From: Amanda Scholes on behalf of Planning.Responses
Sent: 15 March 2018 08:51
To: Planning Scanning
Subject: FW: BR/9/18/PL - Information request

From: Katie Kurek [<mailto:katie.kurek@westsussex.gov.uk>]
Sent: 14 March 2018 14:44
To: Andrew Wood
Subject: RE: BR/9/18/PL - Information request

Following your comment dated 05/02/2018 relating to application no. BR/9/18/PL – Change of use of pavement to front area to accommodate 3 No. removable tables with chairs & cafe barriers. This application may affect the setting of a listed building.

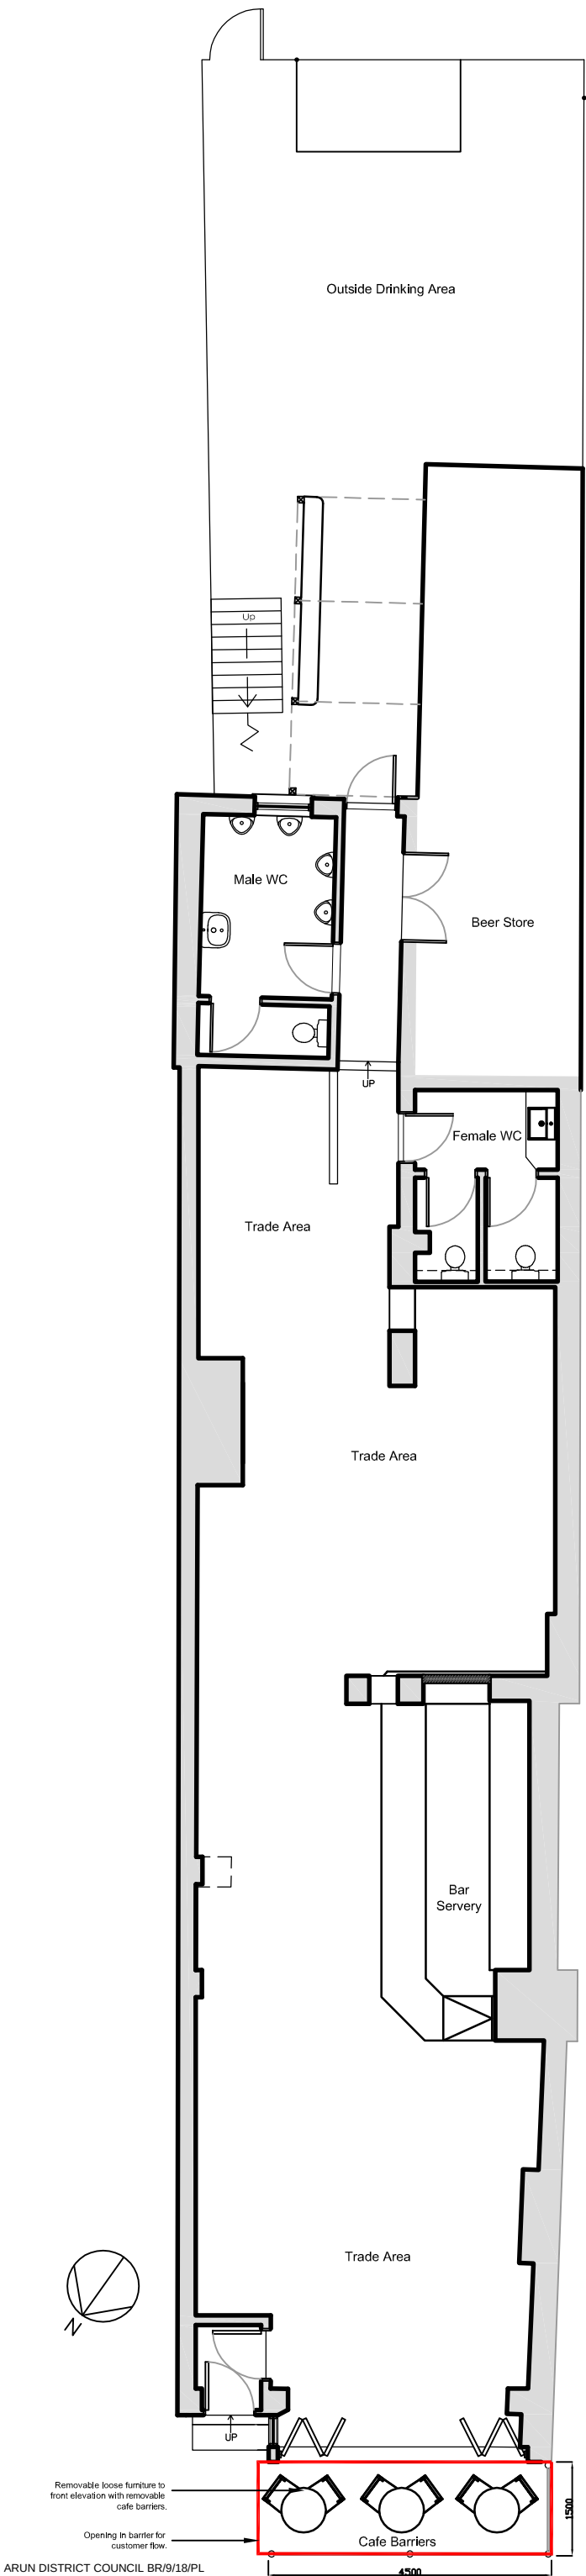
I have heard from the Arun Area Engineer who has advised that the tables and chairs placement, as shown in the photo would not raise a concern. The LHA are satisfied that sufficient footway width would remain to not impact upon pedestrians and therefore no highway safety concern is raised to the proposals. The A-board may be unlicensed and would not be covered by the tables and chairs licence and should not legally be in place on the highway. From a pedestrian safety point of view this should be removed as it further reduces the available footway width.

I am just waiting to hear back from the Area Engineer for his views on the granting of a tables and chairs licence in this location and his views on placement of the A-board which from this photo appears to be within the public highway. I will provide you with additional formal comments in due course.

The placement of the A-board is a separate issue for which planning permission is not being sought in this application. I would however be happy to add an informative to the final planning permission advising that it should be removed as it does benefit from planning permission and may be subject to enforcement.
